**Item No.**                      **Report of the Head of Development Management and Building Control**

**Address:**                      5A BARNARD GARDENS HAYES

**Development:**                Conversion of roofspace to habitable use to include a rear dormer and 3no. front roof lights. conversion from hip to gable end

**LBH Ref Nos:**                78396/APP/2023/3233

Proposed Plan and Elevation:

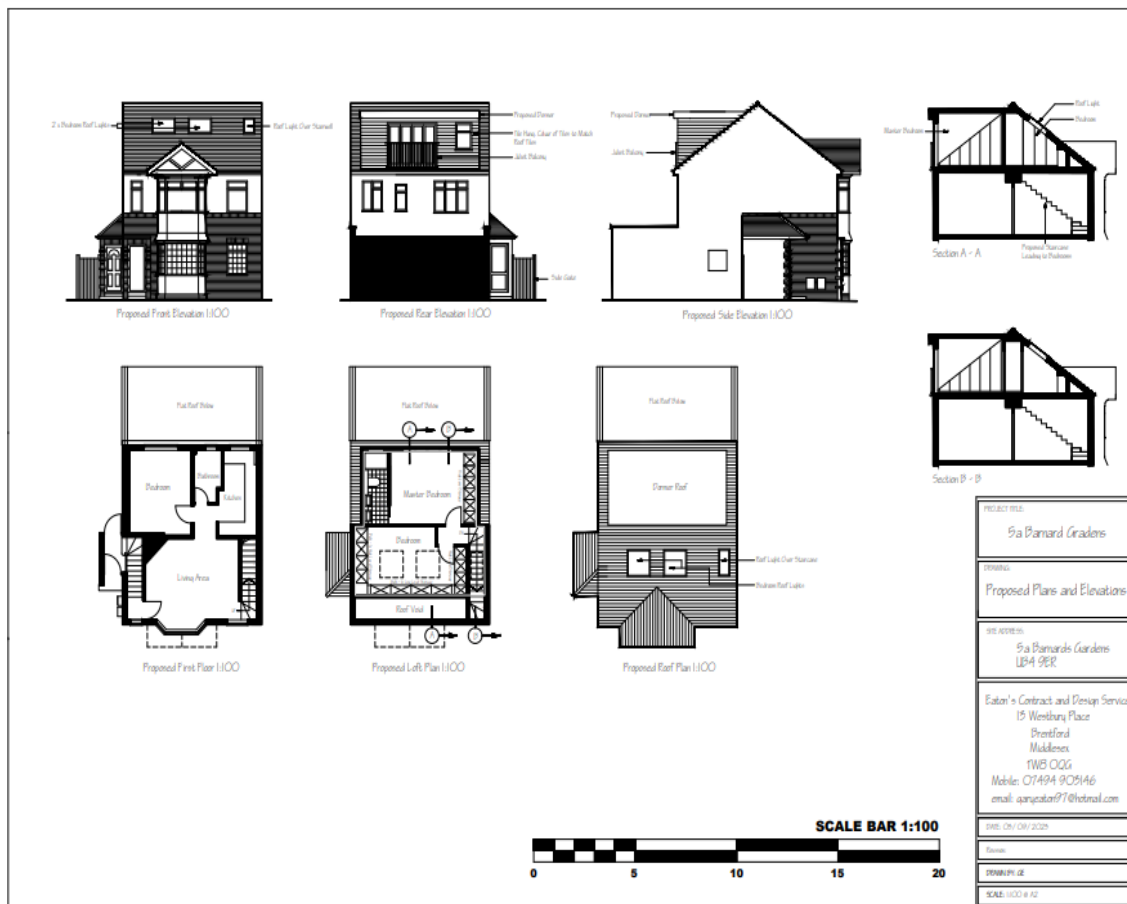
The application proposes a hip to gable and rear dormer loft extension to facilitate an addition bedroom to the first floor flat. As set out in Policy DMHD 1 roof extensions should be located to the rear. The proposal for a hip to gable extension would therefore contravene Policy DMHD 1 and in particular point i) and ii). The proposed plans indicate that the rear dormer would expand into the proposed new gable end thus extending beyond two thirds of the original roof form.

Taking these points into consideration, the extensions would fail to appear subservient to the host dwelling and would appear over dominant and harmful within the local context, given that the prevailing character comprises of mainly hipped roofs. It is therefore considered that the proposal would comply with Policy BE1 of the Hillingdon Local Plan: Part One Strategic (2012) and Policies DMHB 11, DMHB 12, and Policy DMHD 1 of the Hillingdon Local Plan: Part Two - Development Management Policies (2020).

No.7.A is located directly beneath the application property and is therefore the principle property which requires an assessment. The development would involve the installation of rear facing windows at roof level which would overlook the rear garden of No.7.A. The objection received during the public consultation period regarding privacy and overlooking concerns is noted however it is clear that the existing first floor rear facing windows would already overlook the rear garden. The proposal for additional windows at a higher level is not considered to give rise to significant additional harm. As such the proposal is would not result in detrimental harm to the residential amenities of neighbouring properties.

The proposed development, by reason of the design and excessive size, scale and bulk of the hip to gable and rear dormer would result in an incongruous and visually obtrusive form of development which would fail to respect the architectural composition of the original dwelling and would be detrimental to the character and appearance of the street scene and surrounding area. The proposal is therefore contrary to Policy BE1 of the Hillingdon Local Plan: Part One - Strategic Policies (2012), Policies DMHB 11, DMHB 12 and DMHD1 of the Hillingdon Local Plan: Part Two - Development Management Policies (2020), Policies D1, D3 and D4 of the London Plan (2021) and the National Planning Policy Framework (2021).
